DRB Application No.: 04DRB 01626(SDP) Project # 1003742
Project Name: Ladera Business Park
Agent: Shiner Construction Phone No.: 344-3461

**DEVELOPMENT REVIEW BOARD
ACTION SHEET**

Date: 25 October 2004
To: Sheran Matson, DRB Chair
From: Russell Brito, Senior Planner
RE: Project # 1003742: 04DRB-01626 (EPC Project#1001523: 01123-01405)

SITE DEVELOPMENT PLAN

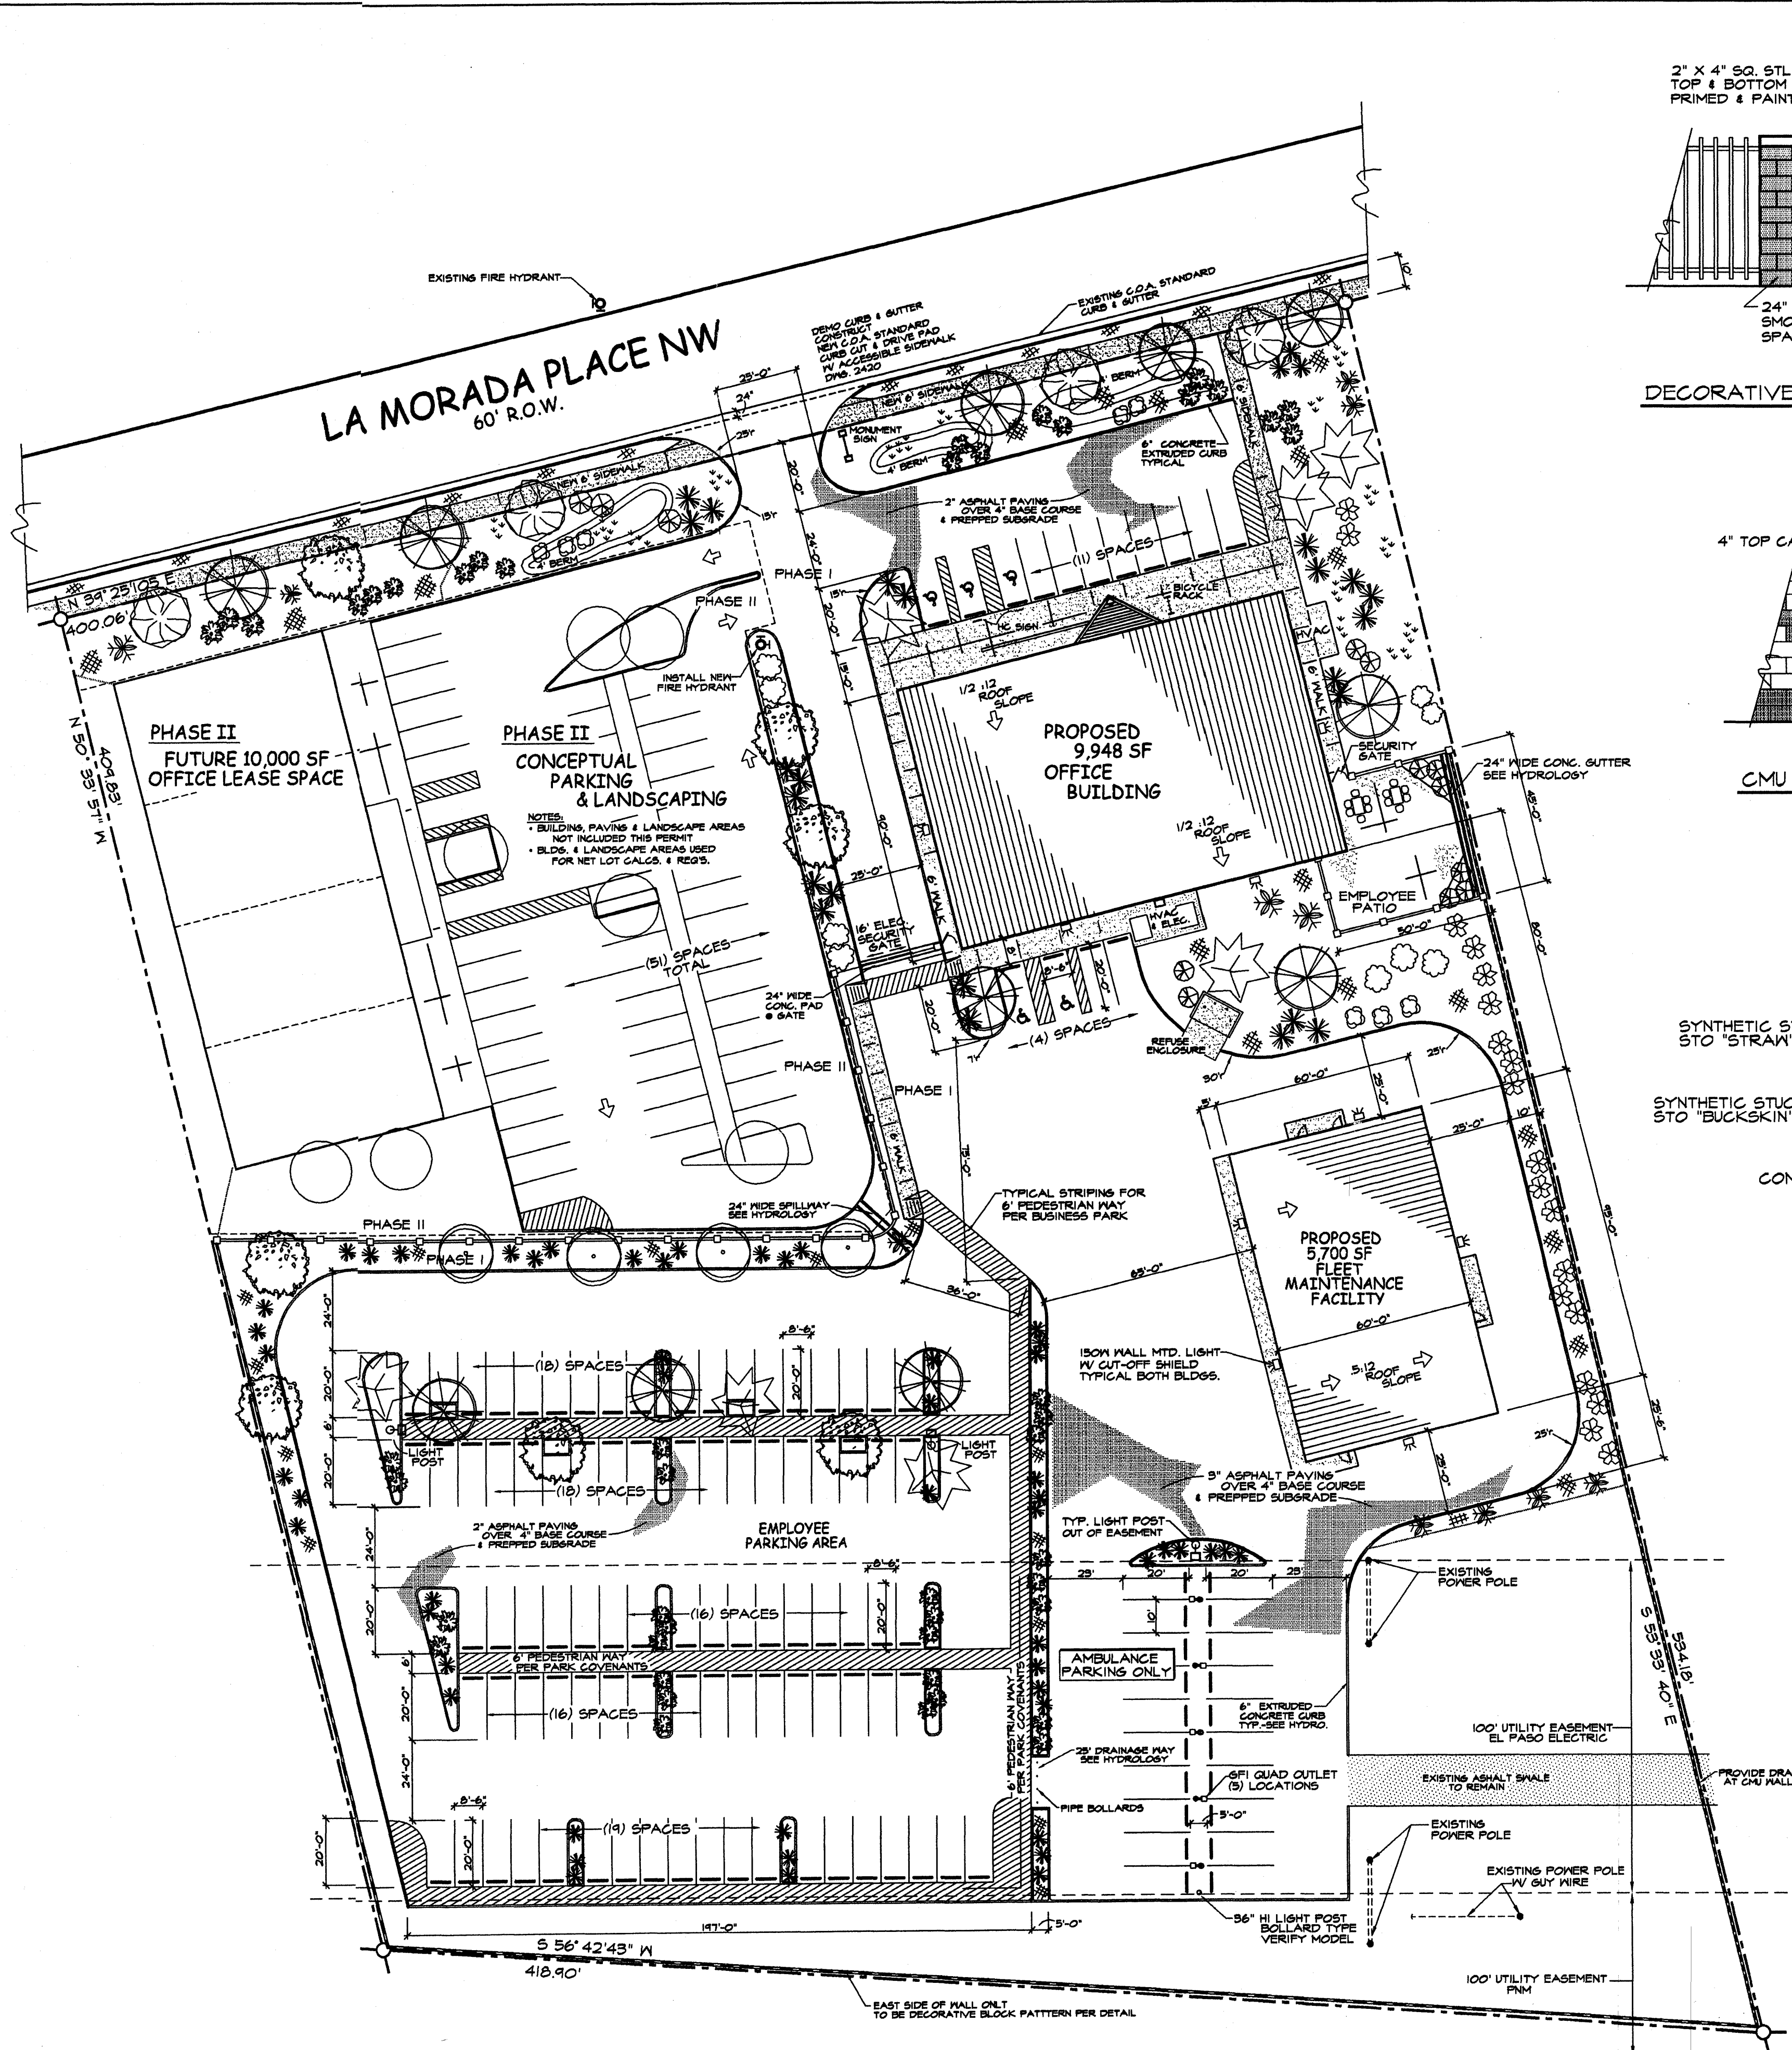
The submitted site development plan for building permit appears to generally meet the design requirements for the Ladera Business Park. But, some clarifications and additions are necessary, including:

2. All pedestrian walkways shall have adjacent trees spaced approximately 25 feet on center.
3. Show a designated pedestrian connection between office building and maintenance building.

4. Show a designated pedestrian connection between office building and Phase II office lease space building.
5. Show and provide a pedestrian connection from sidewalk along La Morada Place to Phase II office lease space building.

6. Show dimensions of parking end islands; dimensions shall meet DPM standards.
7. Label, detail and show landscaping treatment along south and east boundaries of the site within El Paso Electric and PNM easements, including irrigation system.

LANDSCAPE PLAN

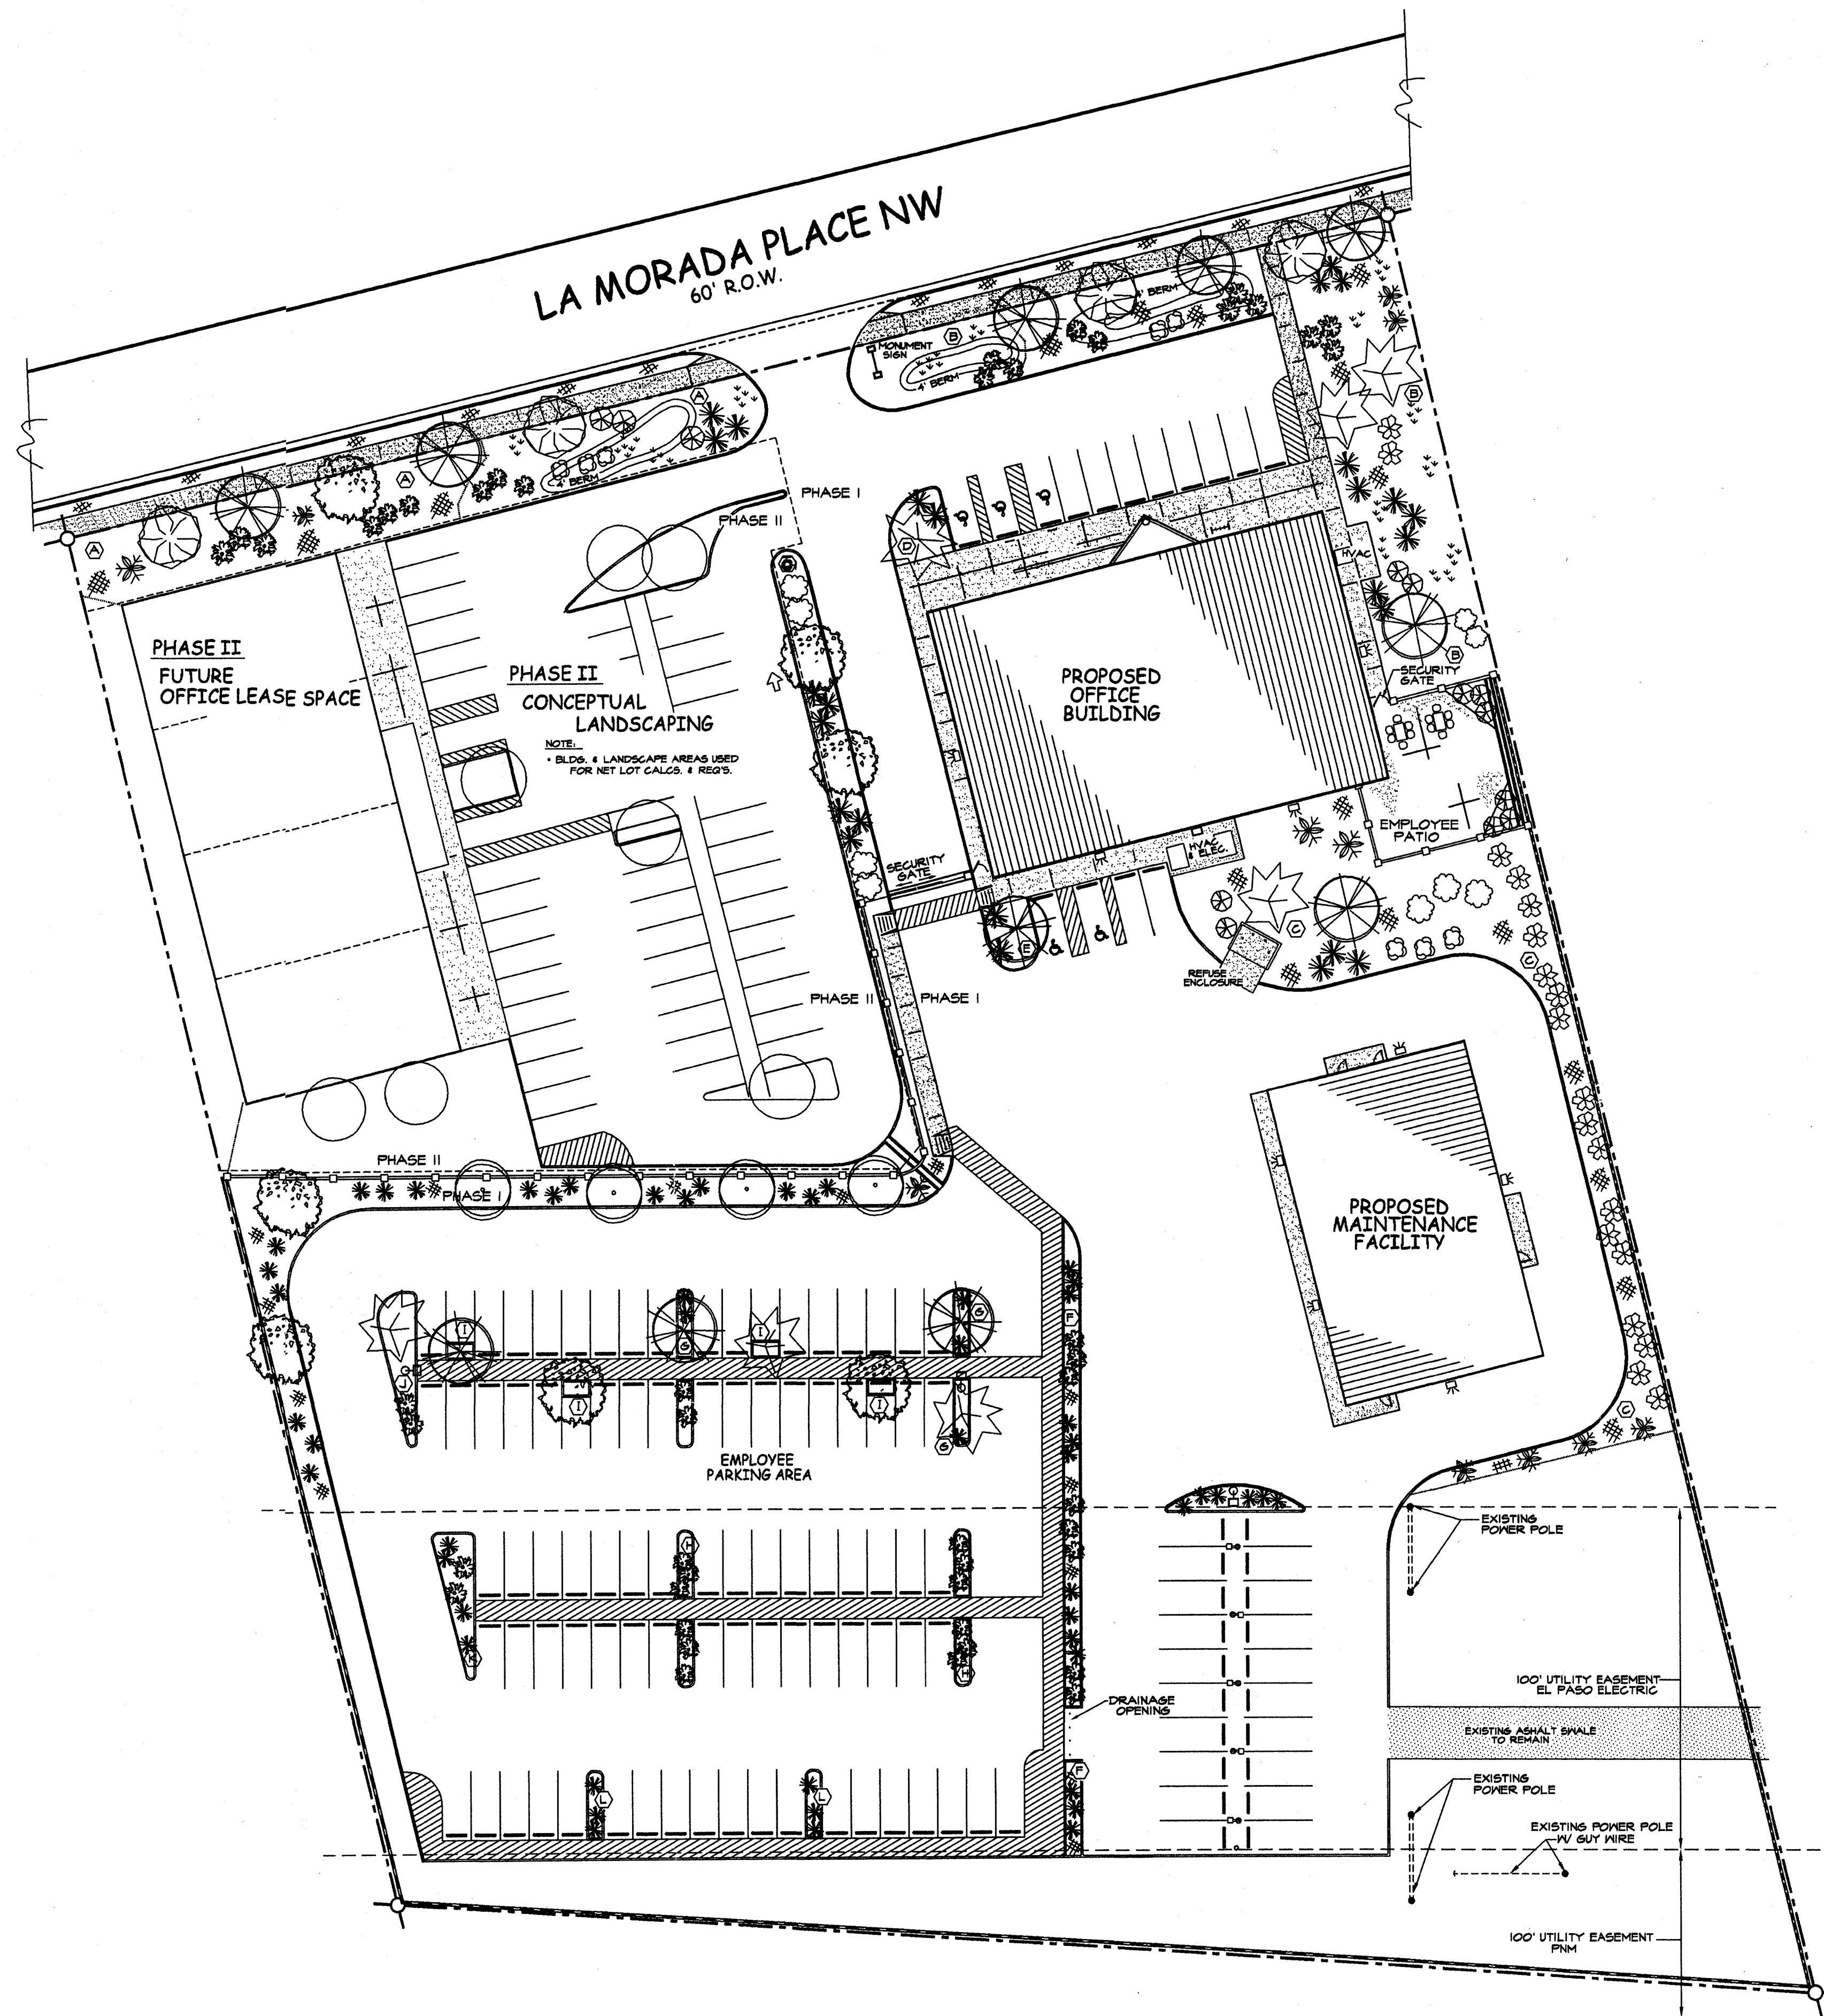
1. Label, detail and show interim landscaping treatment for the Phase II development area (e.g. native grass and wildflowers with temporary irrigation system).
